From: Anita Gardner
Sent: 21 February 2019 18:08
To: Planning.Responses
Subject: FW: LU/357/18/PL - 18-22 East Street, Littlehampton, BN17 6AW

From: Kate Giddings
Sent: 21 February 2019 17:27
To: Anita Gardner
Cc: Anna Appleton
Subject: LU/357/18/PL - 18-22 East Street, Littlehampton, BN17 6AW

Drawing Title
Existing - Plot 22
Lower Ground, Ground &
First Floor.

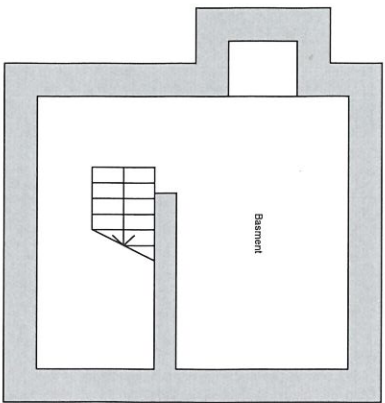
- More details is required regarding the proposed plant room occupying the lower ground floor of no. 22 East Street (including the type of plant, hours of operation, noise-reduction measures, etc.)
- Works of demolition or construction, including the use of plant and machinery, necessary for the implementation of this consent shall be limited to the following times:
 - 08.00 – 18.00 hours Monday to Friday
 - 08.00 – 13.00 hours Saturday
 - No work permitted on Sunday or Bank Holidays
